Our reference: GB/661
Please reply to: Tim New/Geoff Card

Proposed Lidl Store, Bankwood Way, Birstall, West Yorkshire

GB Card & Partners (GBCP) have been commissioned by Beam Consulting Engineers Ltd (Beam Consulting) (the Client) to undertake a geotechnical assessment of the proposed ground improvement works at the above site.

DRAWING NUMBER	REVISION
09-148-404	D

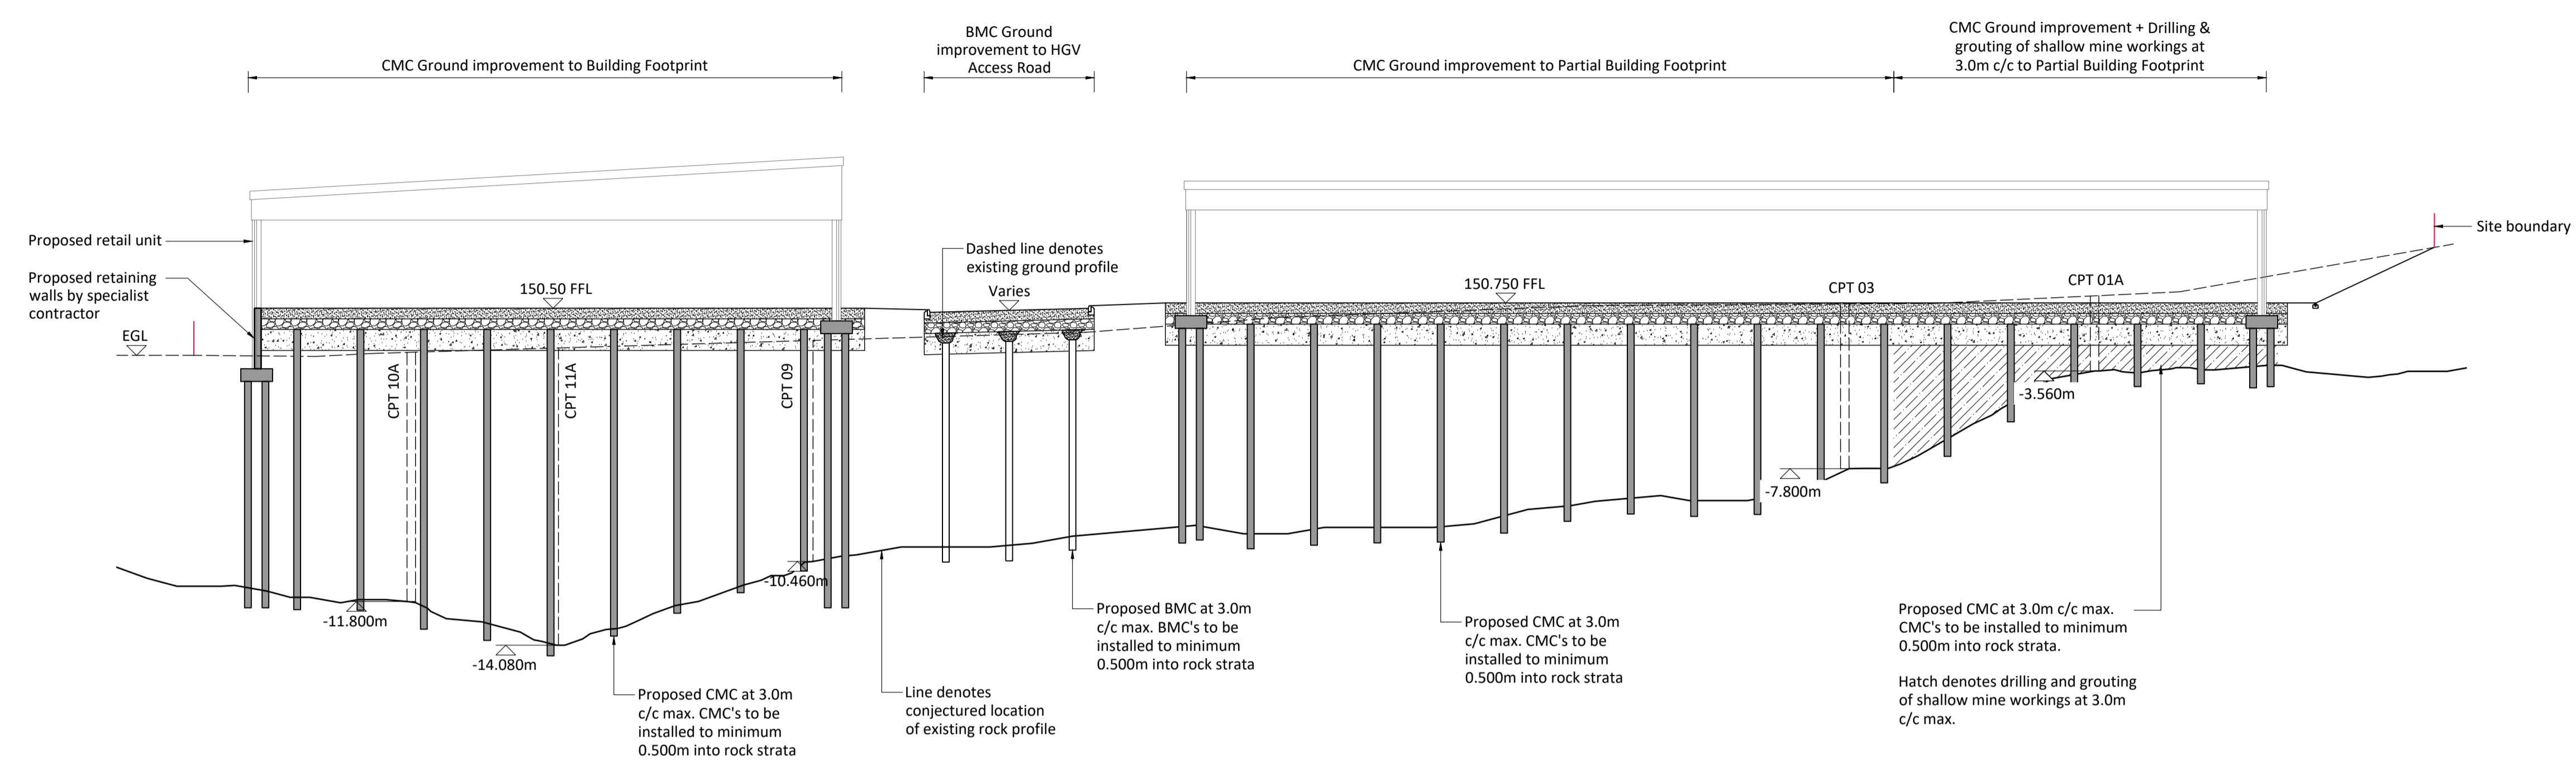
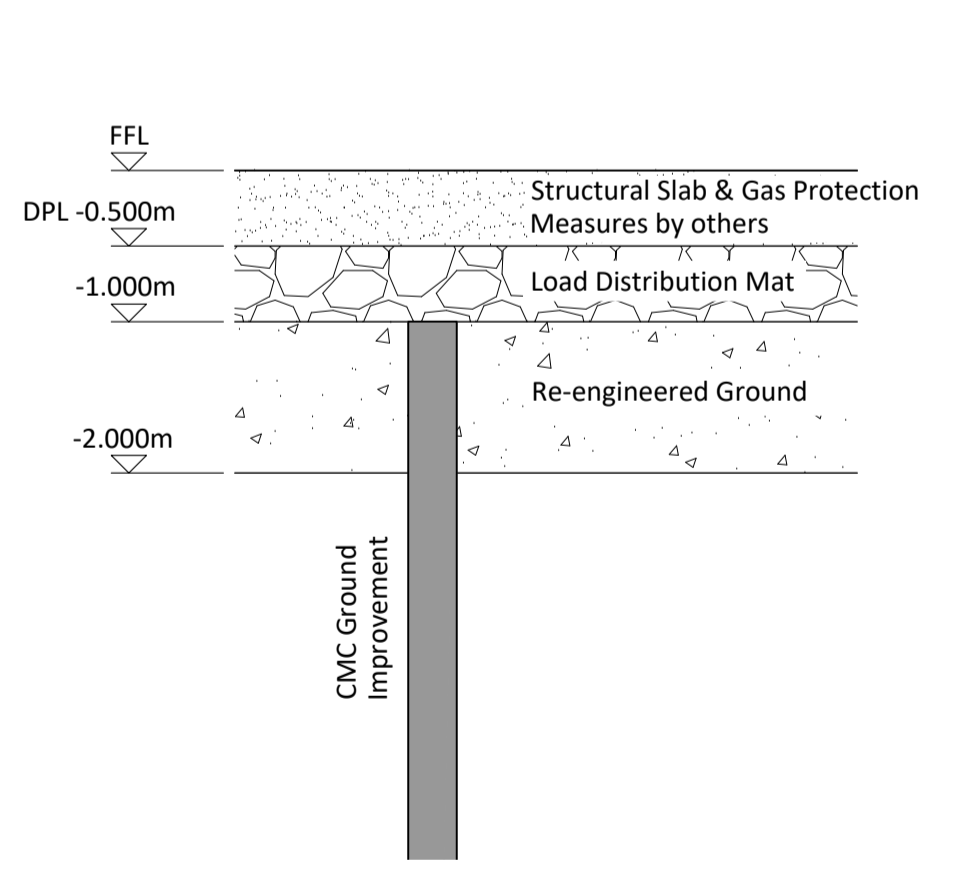
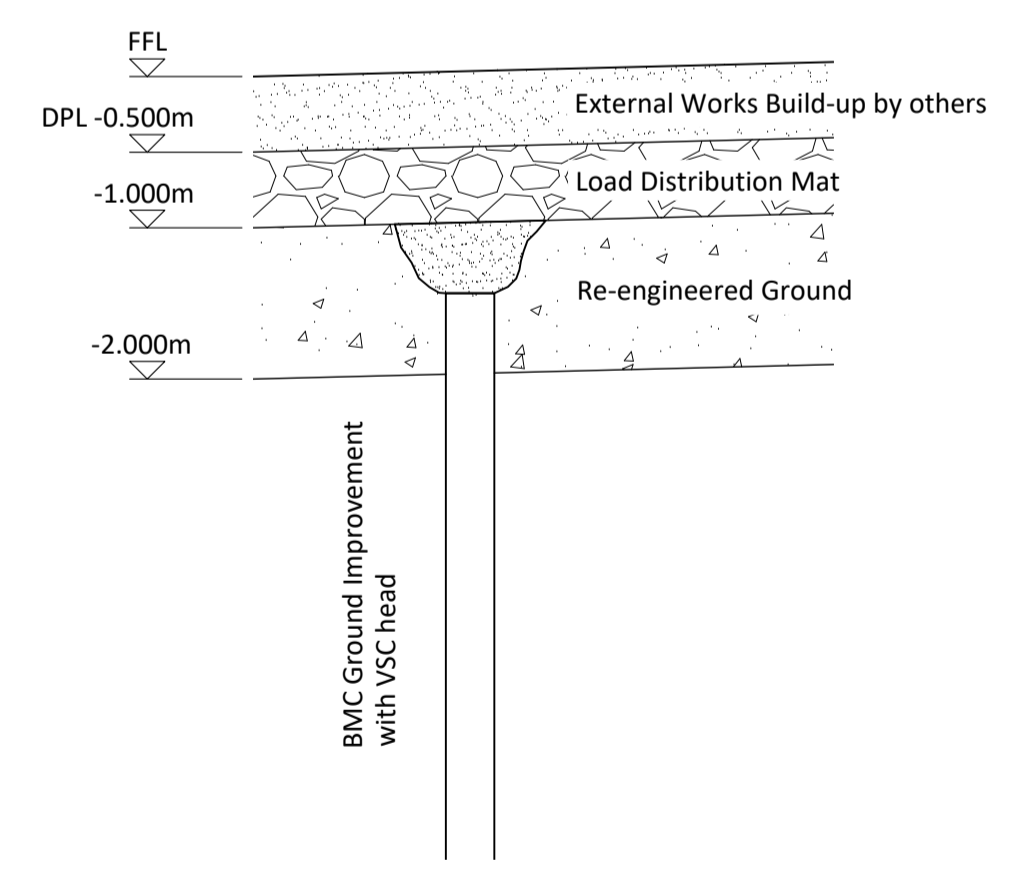
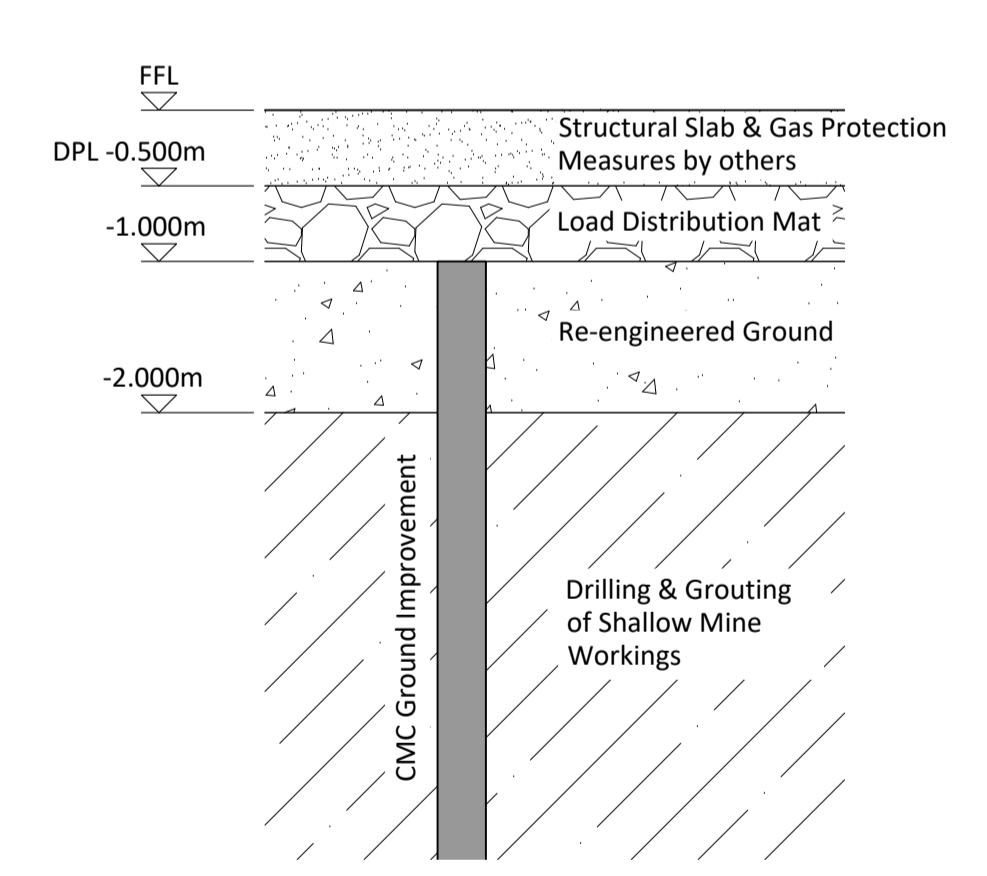
1. The profile of the Pennine Lower Coal Measures Formation varies significantly across short distances. It will therefore be necessary to consider how the base of the columns will be installed without deflection and with sufficient penetration into competent natural material around the edge of the former opencast workings, where interacting with the highwall.

2. It is noted that the waste is described as being within a clay matrix. The clay matrix will generally dominate the geotechnical engineering behaviour of the waste albeit variation will occur given the heterogeneity of the material composition. With landfilling at the site potentially continuing until the early 1990s, it is possible that any biodegradable putrescible materials in the waste are still degrading, albeit most of the degradation should have occurred over the past 30 years. Following improvement, the long-term residual degradation of landfill waste materials, resulting in potentially uneven loss of strength within the soil mass, should be considered. Where long-term settlement occurs within the waste mass, confirmation should be provided that any reduction of support and/or movement will not adversely affect the proposed solution, resulting in excessive movement or collapse of the stone column section.

3. It is acknowledged that anticipated total and differential settlements are to be reduced through the application of the proposed method. It is recommended that the design considers the transition between differing foundation types (CMC's/BMC's) to minimise potential differential movements and to maintain transition gradients within acceptable tolerances. It is anticipated the use of the load transfer mat will mitigate the majority of these potential effects.

4. The potential for ground gas migration, particularly within the vibro stone column element of the BMC columns, should also be considered when designing the system. For example, it may not be feasible to locate the base of the stone columns within the landfill waste material, encountered from depths as shallow as 0.8m bgl, which may mean varying the depth of the stone columns across the site.

5. It is understood that the identified shallow mine workings are to be treated by injection grouting prior to ground improvement works taking place. The interaction between the treated mine workings, including the adit recorded in the northeast of the site, but not identified by either ground investigation, and the ground improvement works should be considered to ensure the performance of the ground treatment is not adversely affected.

6. Excessive heave should be mitigated against during the ground improvement works, as this will reduce the effectiveness of the improvement of soils surrounding the columns. It is assumed the surcharge loading from the addition of the load distribution mat will be minimal and supported by the columns and will therefore not significantly increase consolidation settlements.
